Response to LPA Comments on Appellant's Statement of Case

Ref: APP/R5510/W/21/3271814

Appeal by Mr Jazvinder Sokhi

Site Address: 1 Adelphi Crescent, HAYES, UB4 8LY

Figure 1
Open gap between 1 Adelphi Crescent and 3 Adelphi Crescent

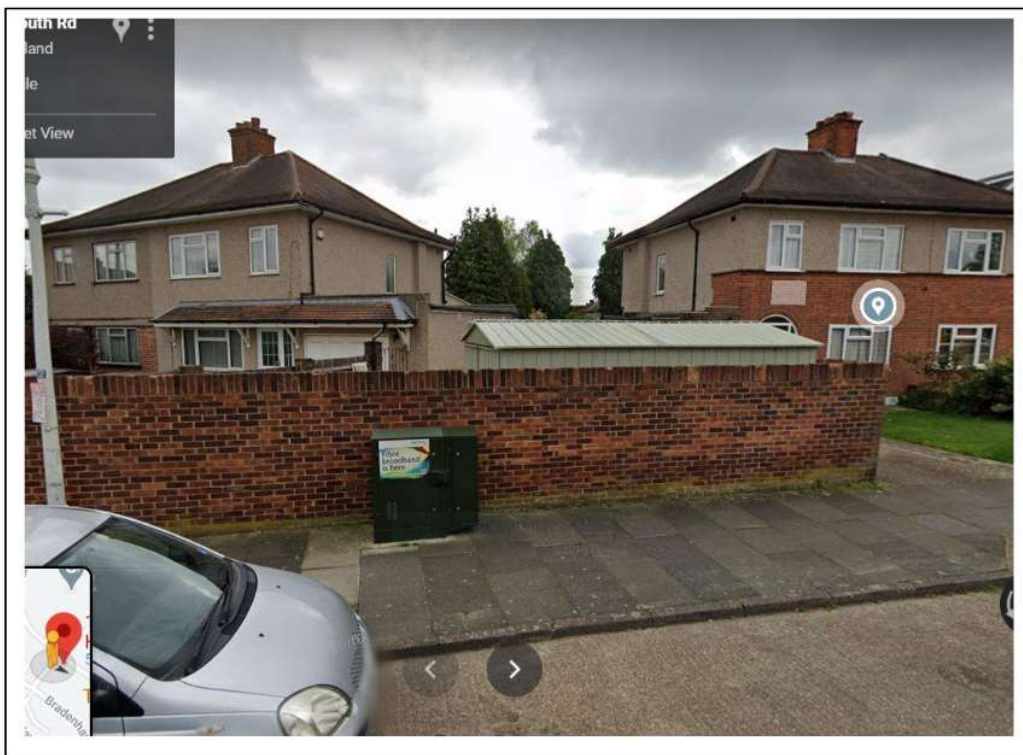
2.1 The Council disagrees with the appellant that the proposed development would not appear as a cramped form of development and would respect the established character of the area for the reasons set out in Section 7.2 of the attached delegated report.

2.2 In response to the Council's concerns about the position of the proposed dwelling in close proximity to the boundary resulting in the loss of space on this prominent corner plot, the appellant has provided examples of extensions to the side of other properties in the area and tabled their open space area to the side and length along the street. However, these are single-storey extensions that are visually subordinate

to their respective dwellings. Conversely, the proposal is for a two-storey dwelling that would enclose this important visual gap both in area and vertically, appearing unduly cramped within the site. Therefore, the Council maintains that the proposed dwelling would by reason of its siting in this open prominent position, size, scale, bulk and design would be detrimental to the character, appearance and visual amenities of the street scene and the wider area as set out in section 7.2 of the officer delegated report.

We have clearly demonstrated in drawing No: FDC/20/04/12a submitted that our proposal respects the important visual gap characteristic to the area.

The position of our proposed block to the front and rear forms an alignment with No's 3, 5, 7, 9 Adelphi Crescent etc as demonstrated on proposed street elevation, drawing No: FDC/20/04/09a. The proposal is similar to these rows of semi-detached to its left in bulk, scale and appearance, hence on a wider scale street view, it is more associated with the row of semi-detached block to the left than No 1 Adelphi Crescent.

The proposal does not form an attachment to the host building hence it would not be subordinate to the host building. We believe that the statement by the LPA that (*neighbouring building extensions are single-storey extensions that are visually subordinate to their respective dwellings*) does not describe the appearance of the proposed street setting. The visual gap between the host and proposed building from the street is approximately 15 meters compared to similar settings which are at most 11 meters wide.

Figure 6

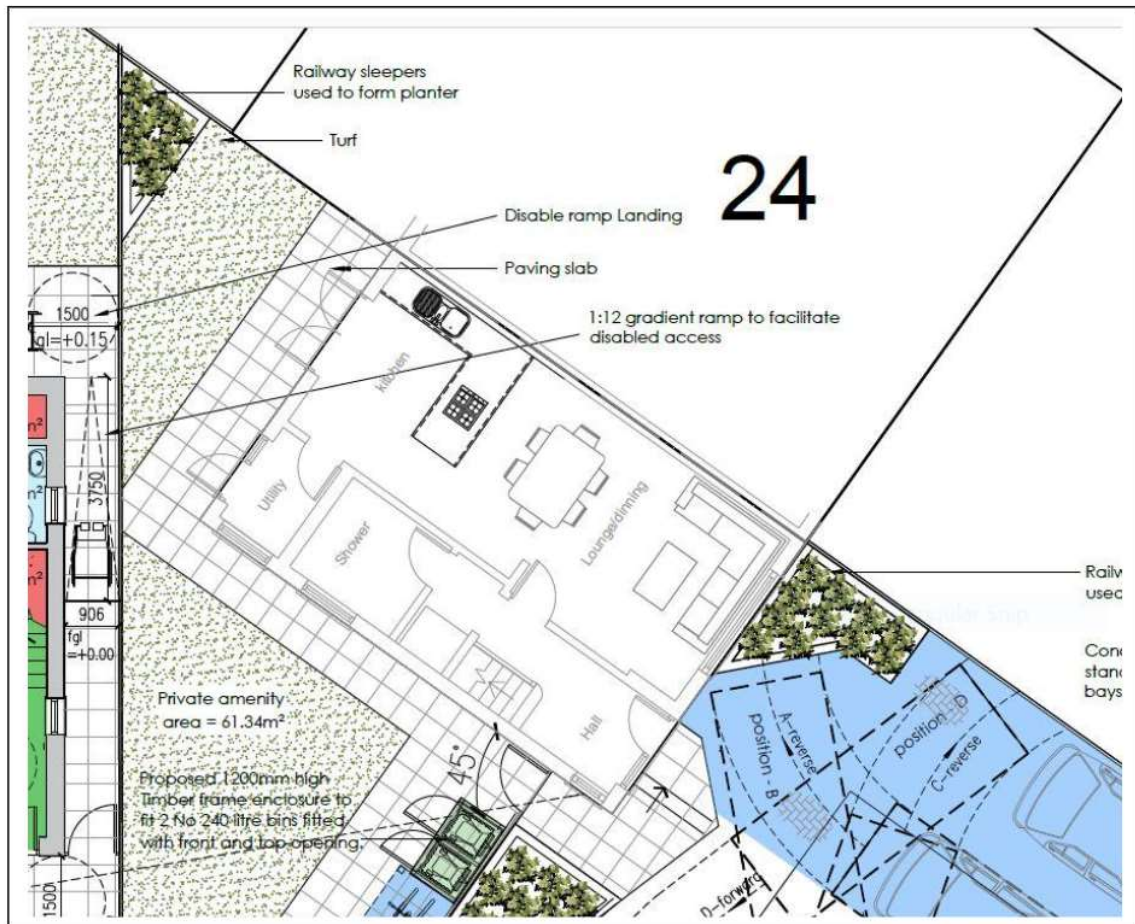
2.3 The appellant maintains that the windows in the host dwelling, most affected by the proposal, serve non habitable rooms or rooms that are served by another light source. However, it is not only light provision that the Council raises concerns but also visual intrusion, particularly as the separation distance between the two storey elements of the host dwelling and proposed dwelling is just 5.6m. Given the proximity and orientation of the proposed dwelling, the outlook from rear facing windows and

the garden to the rear would be dominated by the proposed dwelling resulting in an unacceptable loss of light and outlook. The private patio area to the rear of the host dwelling would be dominated by the proposed dwelling. Living conditions for future occupants.

The outlook of the proposed building at first floor level has been considered in the proposal even though its proximity and orientation look dominant. The windows closer to the proposed dwelling both at first and ground floor level are to non-habitable room the utility on the ground floor and the family bathroom on the first floor which consists of obscure glazing.

Even though we have shown that the primary light source to the kitchen/sitting/dining area of the host building is from the front window, we have also we demonstrated that the kitchen patio door give a full height outlook to at least 30% amenity space to the rear of the property,

however window to the utility; hall and staircase give further outlook to the other 70% amenity space to the property. We believe the combination of all windows give a fair amount of outlook and serve as a light source to the property.

The patio area suggested to have been dominated by the proposed dwelling only amounts to 30% of the private amenity space provide. The other 70% that is also served by a patio is open to the front of the dwelling as demonstrated on the proposed ground floor plan drawing No: FDC/20/04/07b. We do not agree that the majority of the host building amenity space would be dominated by the proposed dwelling.

Figure 8
Wheel chair access to property

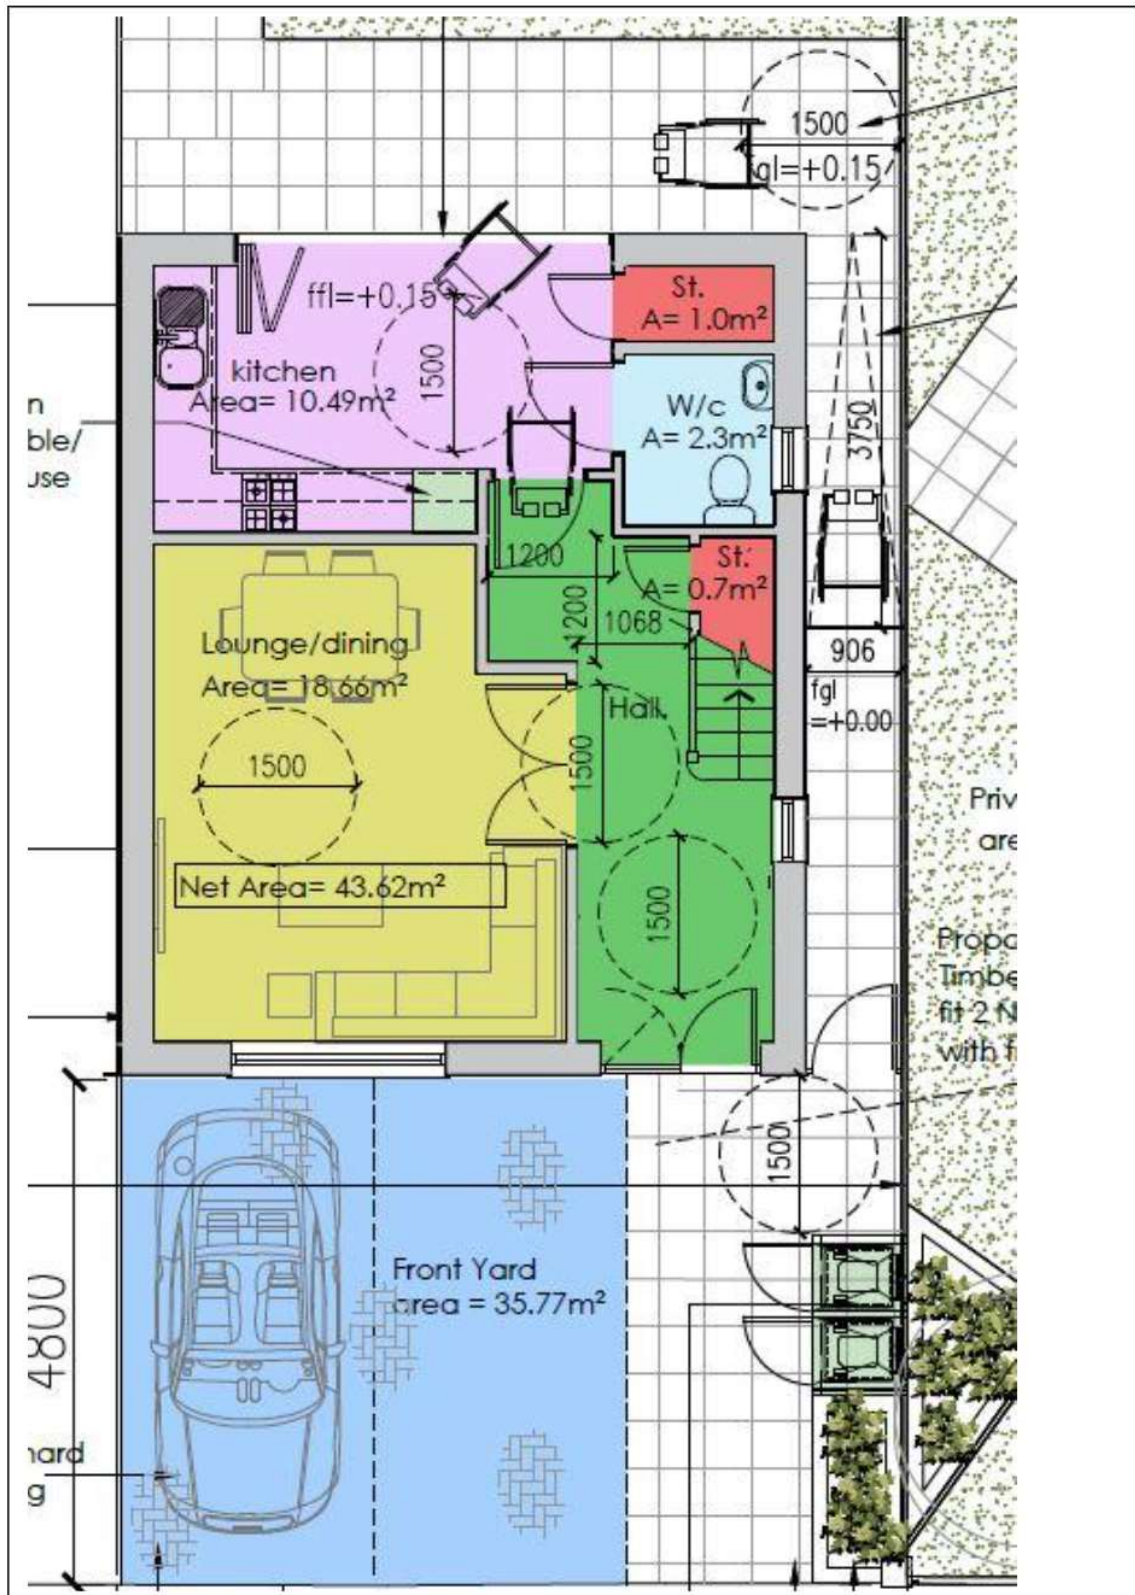
2.5 The Council acknowledges that amended plans have been submitted with the appeal to ensure that the proposed dwelling incorporates design features which are incompatible with the standards required Policy D7 of the London Plan (2021). However, as noted above, the application was refused based on the drawings submitted for the planning application.

Wheelchair access was demonstrated on the last application refused by the local authority Application No: 75616/APP/2020/2866 that was validated on 08/09/2020. The information is on the ground floor plan (Drg No: FDC/20/04/07a) and the design and access statement, section 12; page 30.

We provided a 1:12 ramp leading to the rear of the property and a flush threshold into the property. We also formed the hallway to be wheel chair accessible and a disabled toilet.

Figure 9

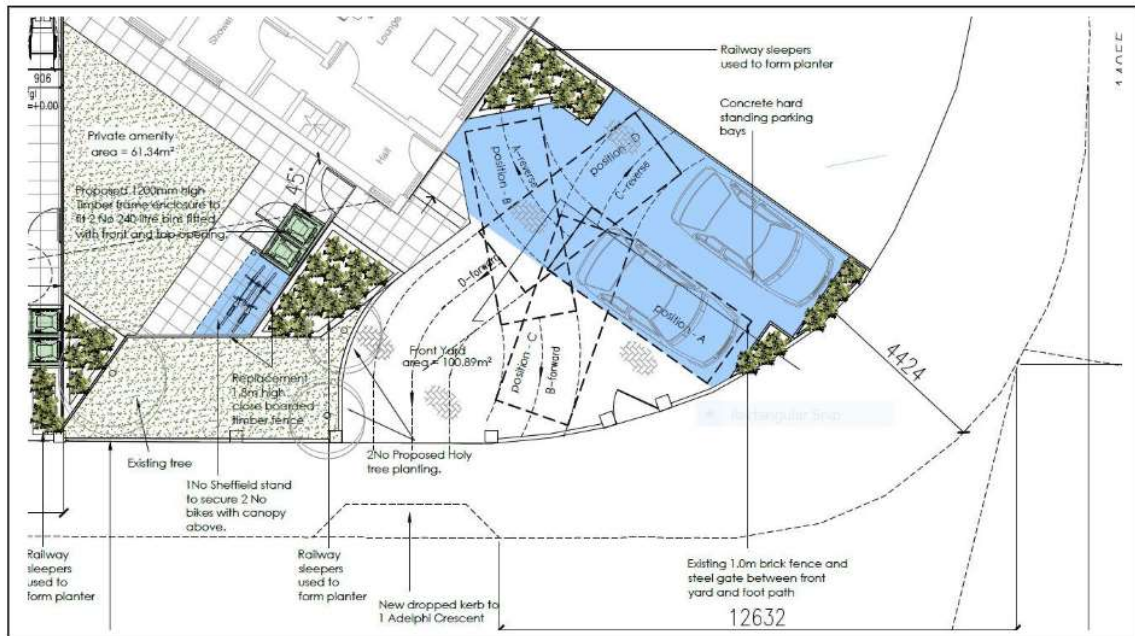
2.6 The Council remains concerned that the frontage of the proposed dwelling would be dominated by hardstanding as set out in section 7.6 of the Officers delegated report.

The provision of a hardstanding much need was very important to this proposal to address onsite parking issues, a driveway was needed because of the position of corner siting of the host site, however we have improved the existing soft landscape area to the existing property by 4 folds.

The soft landscaping to the existing property amounts to 6m², we propose increase this to 26m².

We have not proposed to remove the existing tree on site. We have proposed another 2 trees to the frontage to make a total of 3 trees

We propose introduce permeable block paving to all vehicular hardstanding, this is stated in our design and access statement, section 10 paragraph 10.11.
